### **Re: Northparkes Mine Step Change Project (MP 11\_0060) Response to Submissions**

## Attachment A: OEH response to Northparkes Mine biodiversity issues

### Northparkes Mine Step Change Project

### Comment on the Response to Submissions document

FIGURE 5.14

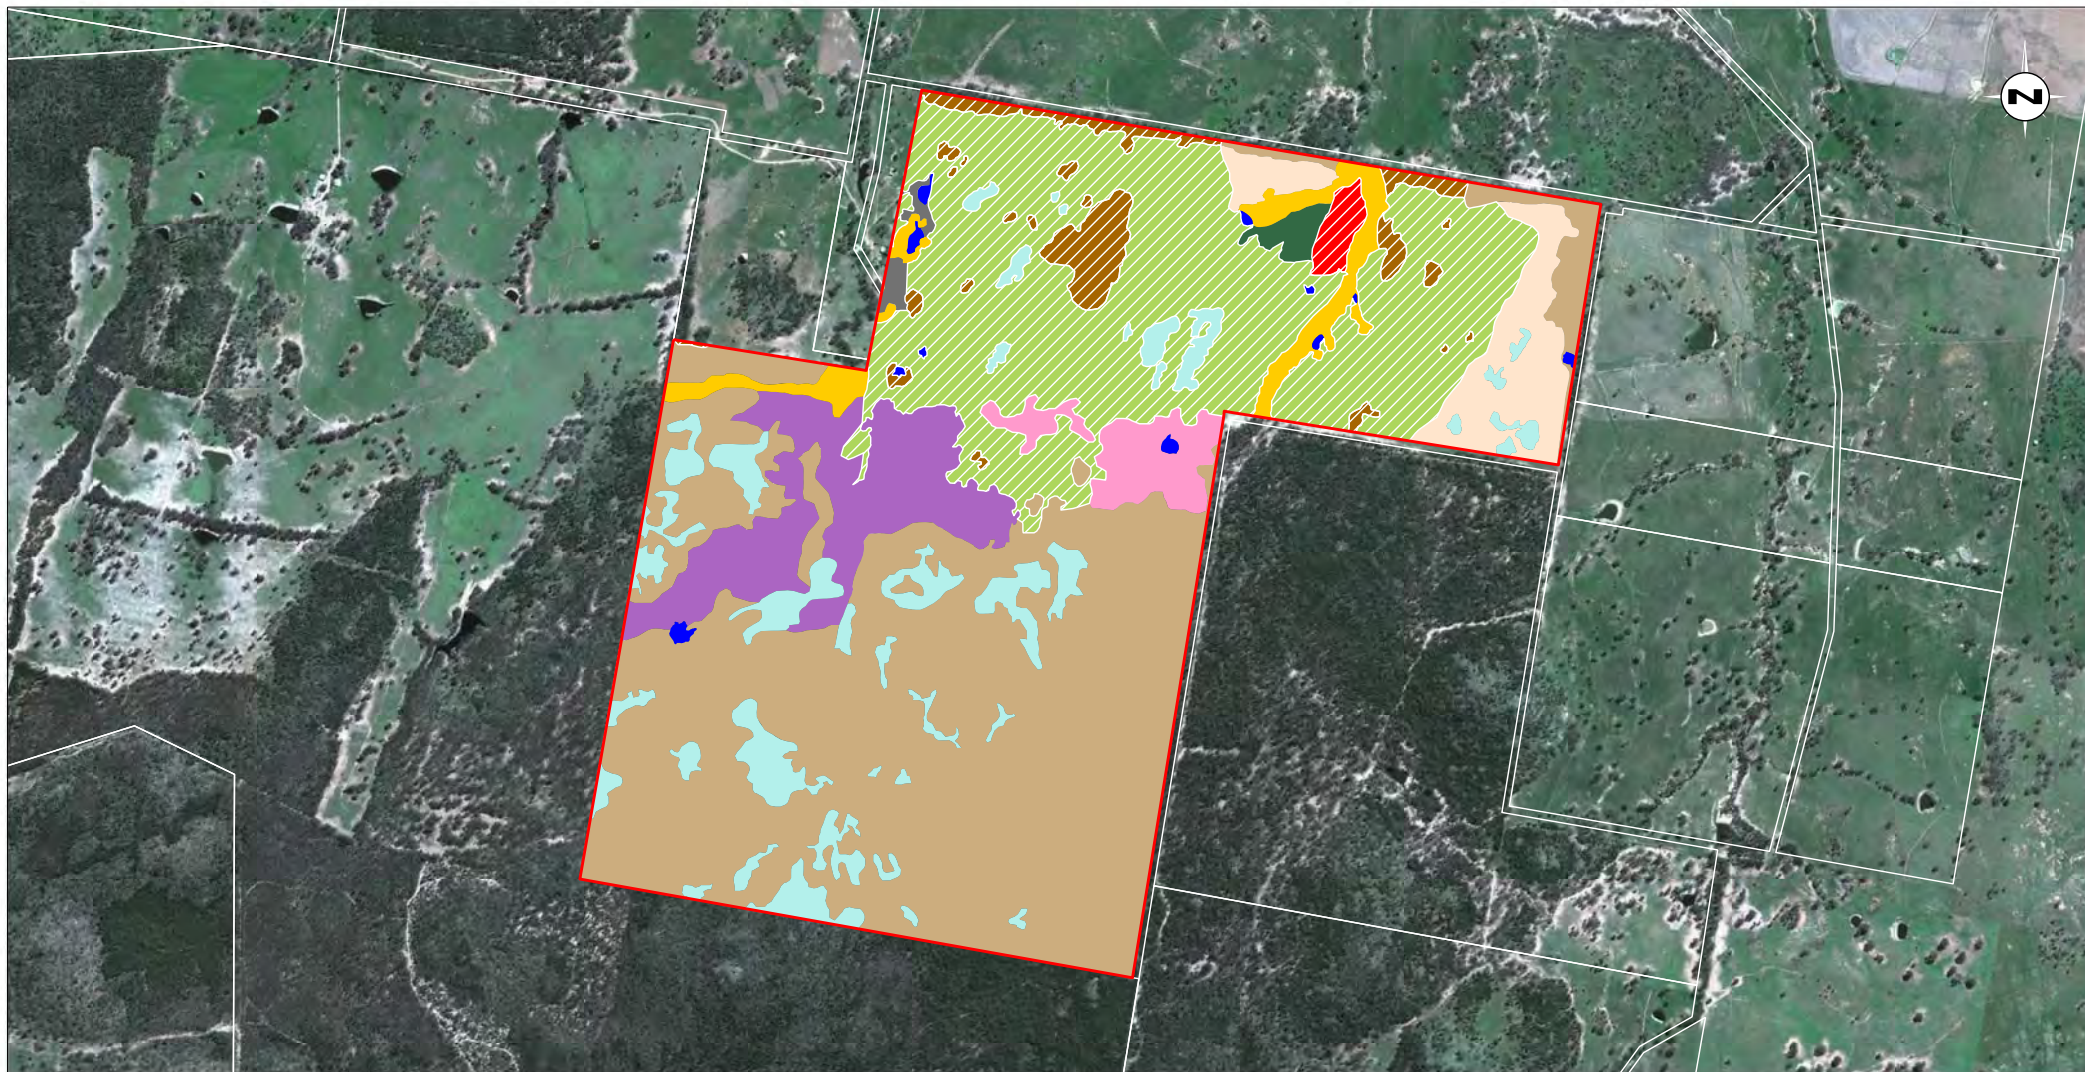
OEH previously identified concerns regarding the proposed conservation mechanism with regards to providing security for the resourcing required for the ongoing management of the offset site, and how the mechanism will reflect who is responsible for the management actions over time. The RTS document indicates that the deed of agreement between the Kokoda landowner and the proponent will be valid over the life of the mine but once mining has been completed the obligations under the covenant will revert to the landowner. OEH's original concerns about this proposal remain. Given that part of the offset strategy for the Project relies on the restoration of an EEC and that management and reporting activities will need to occur beyond the life of the mine, OEH again questions the ability of the proposed mechanism to achieve these outcomes.

- 3.1** The Kokoda offset site should be secured by an in-perpetuity conservation mechanism to the satisfaction of OEH.
